REF: 23/00977/OUT

Location: OS Parcel 9195 North Of Claydon Road
Cropredy

Holding objection

Comments on outline plans provided

DRAWING TITLE
CONCEPT PLAN

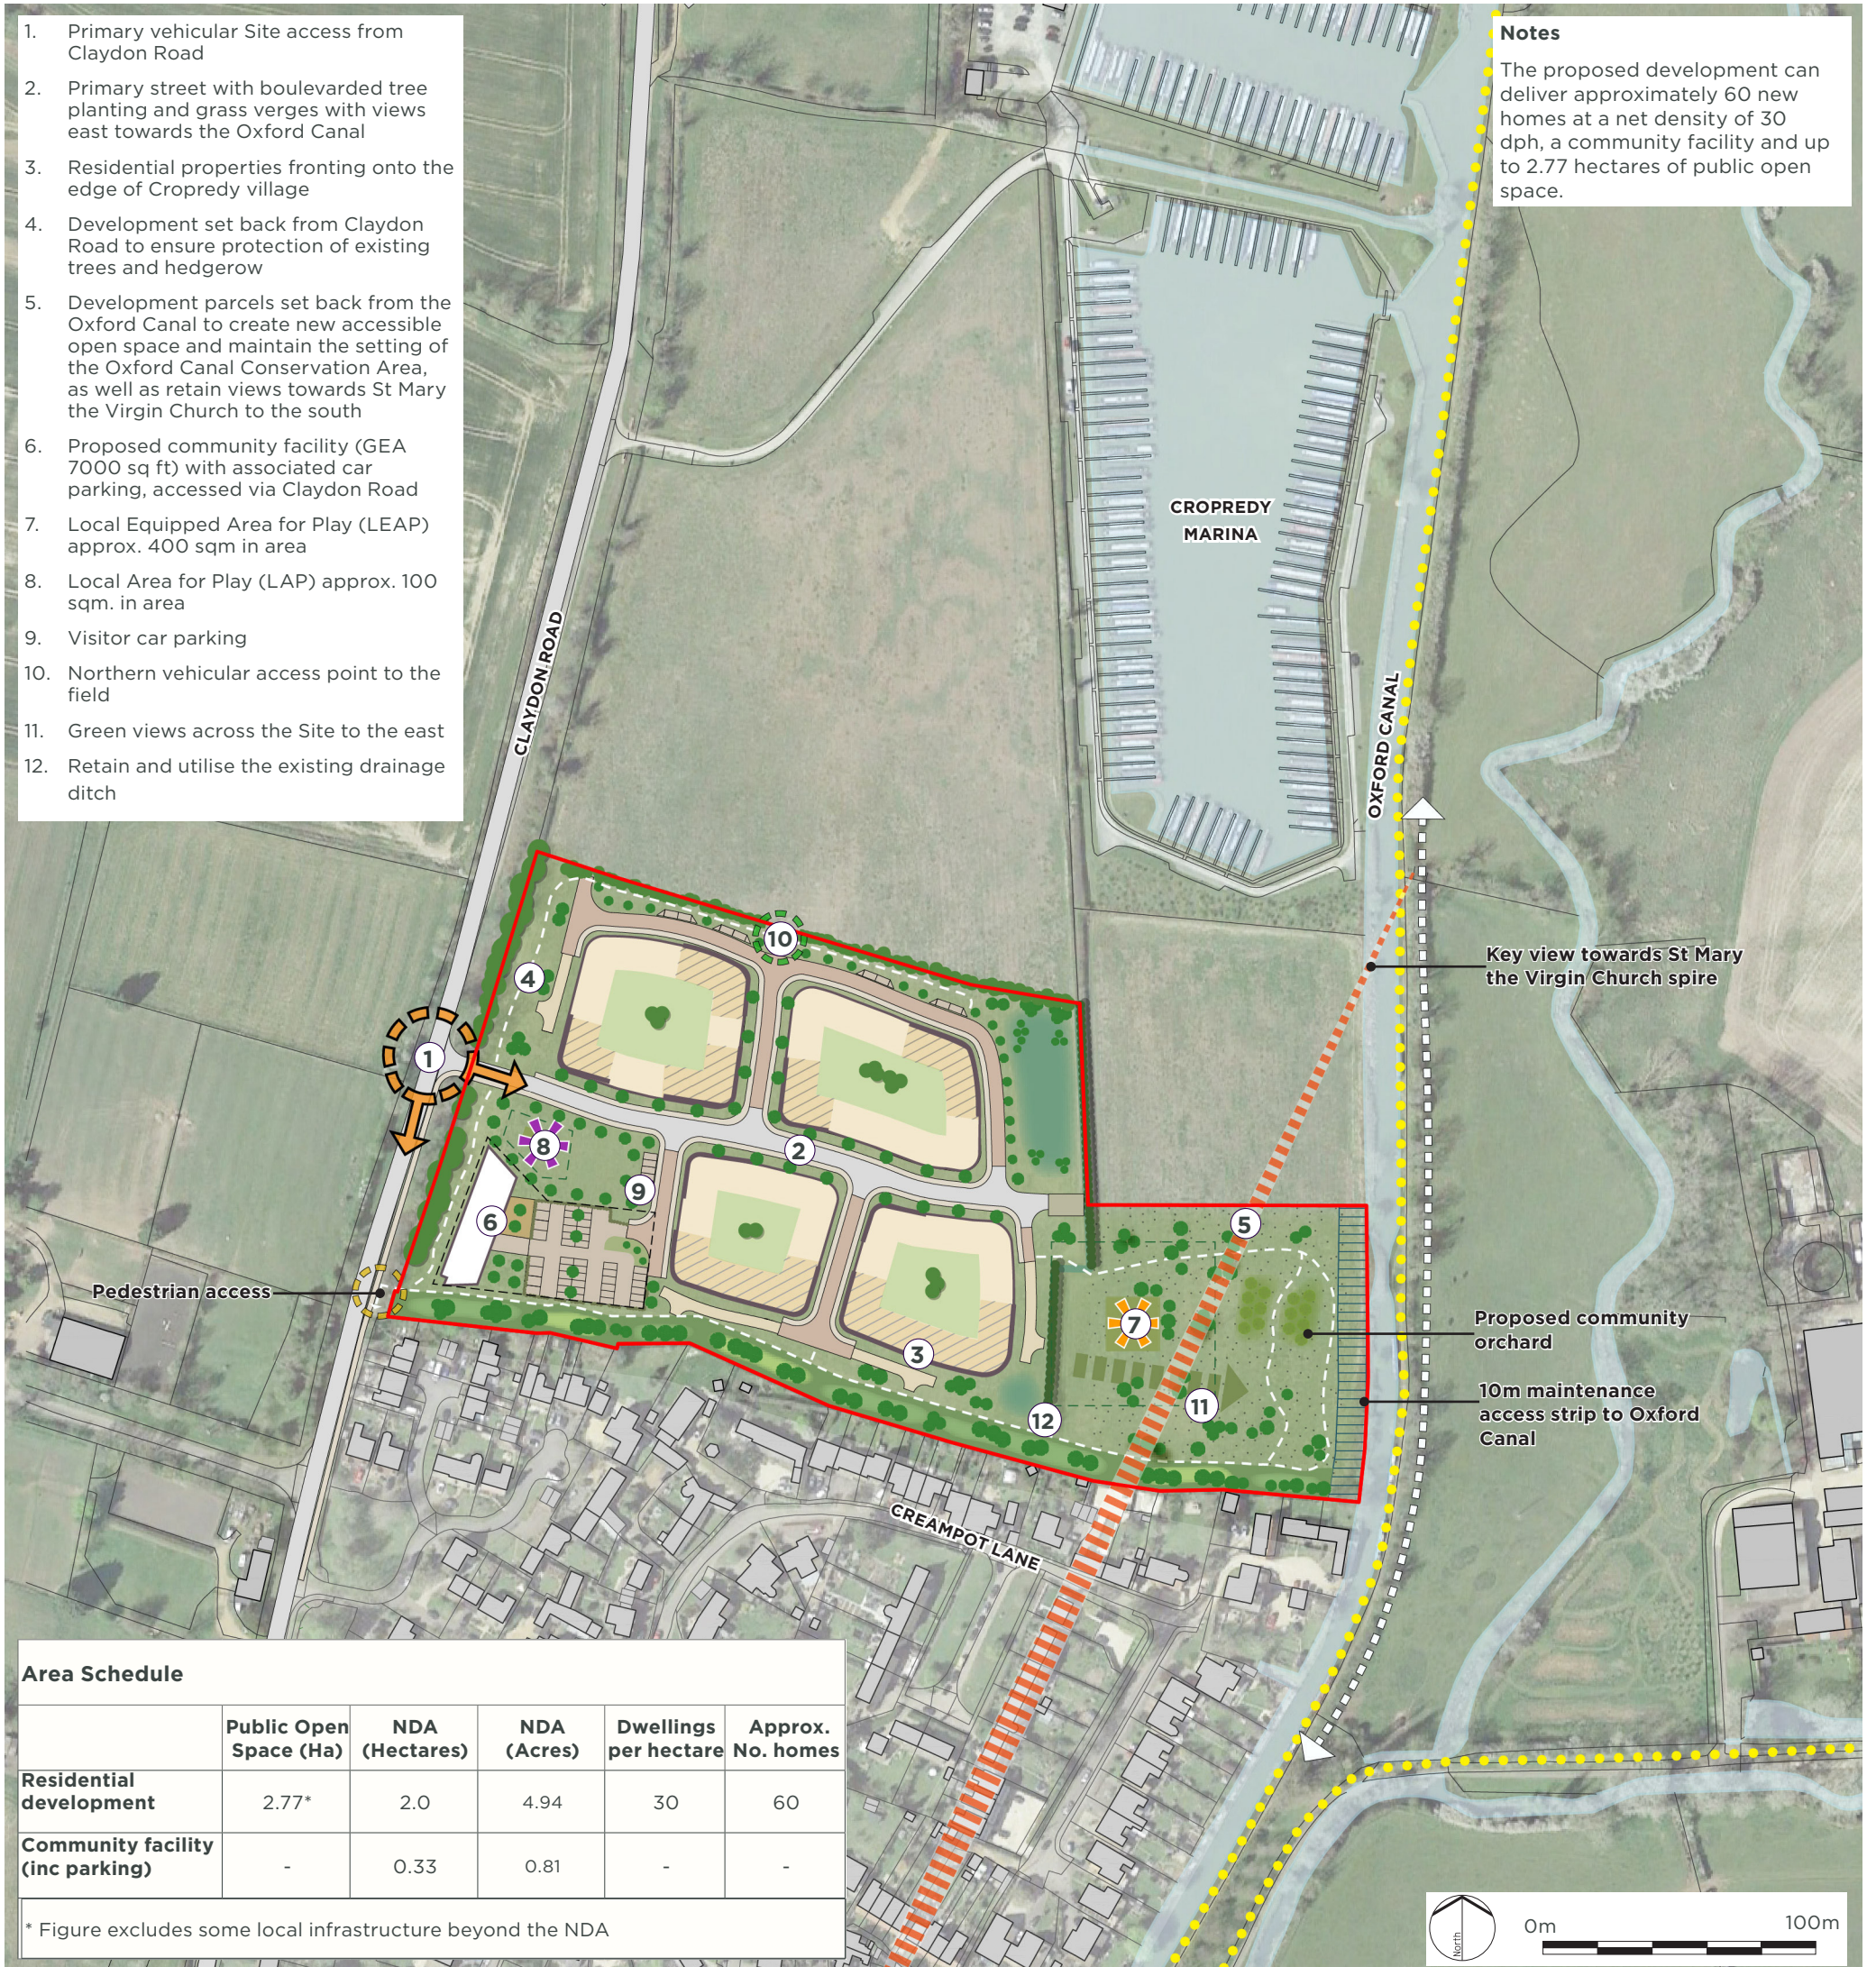
- The community centre car park will be very vulnerable to unauthorised encampments and antisocial behaviour/crime such as flytipping. It is important that it is gated and robustly secured to prevent unauthorised vehicular access outside of the site opening hours.
- The two proposed locations for the LEAP/LAPs leave them at risk of crime and ASB, due to being located away from dwellings where they are not well overlooked. I recommend relocating all equipped play facilities closer to dwellings where they are well overlooked by multiple dwellings, not just one or two or where views are distant.
- Please see further guidance below regarding rear access routes. Ensure all rear access routes are gated in line with the front fascia of the building or as close as possible to prevent any recessed areas between buildings, for example;

- I assume the below diagram illustrates double garages to the rear of two dwellings. This proposal is objectionable, as both the vehicles on the drive and garages would be at high risk of crime due to complete lack of surveillance. The house/garden alignment of these two plots also restricts the surveillance opportunities that these important corner plots provide. I recommend dwellings sit in line with, or proud of their garden boundary, allowing wider surveillance/views over the public realm. This proposed arrangement also provides a long section of dead frontage, significantly reducing surveillance over the public realm and open space. For the same reason, FOGs would not be appropriate in this location due to the lack of active frontage at ground floor level. This section of the development facing onto large swathes of POS must be designed to provide active frontage from as many dwellings as possible to maximise surveillance over the public space. Also see guidance below regarding parking to the rear of a dwelling.

- Another plot design of concern is where corner plots have important side elevations enclosed within garden boundaries, preventing any surveillance from the side aspect, e.g;

I ask that all corner plots are dual aspect to maximise surveillance potential over the public realm, they should sit in line with, or proud of their garden boundary.

- There are many vulnerable side/rear boundaries exposed across the development, with many trees planted alongside exposed boundaries. It is vital that all exposed side/rear boundaries are well protected with defensible space and planting to a minimum 1m depth. I strongly recommend considering the use of thorny species such as Pyracantha or Hawthorne to provide additional physical protection to vulnerable boundaries. All tree planting must be a sufficient distance from dwelling boundaries to prevent trees or their support structures from being used as climbing aids to gain access to rear gardens.

- There are I assume to be 6 visitor parking spaces near to the entrance of the community centre. These spaces are vulnerable, not covered by significant surveillance and where the risk vs reward is weighted in favour of an offender. I ask that all visitor parking is peppered throughout the development in clusters of no more than 2-3 spaces, and where they are well overlooked by surveillance from surrounding dwellings.

- As per further detailed guidance below, please ensure landscaping plans indicate vehicle mitigation measures to prevent vehicular incursion onto areas of green space.
- The 10m tree buffer to the south of the development must include features to protect the rear boundaries of existing development. It is important that these boundaries are protected with a minimum 1.8m high non-climbable boundary, and I recommend deep and thick hedge planting to prevent these boundaries being easily accessible in the wooded area where surveillance will be restricted.
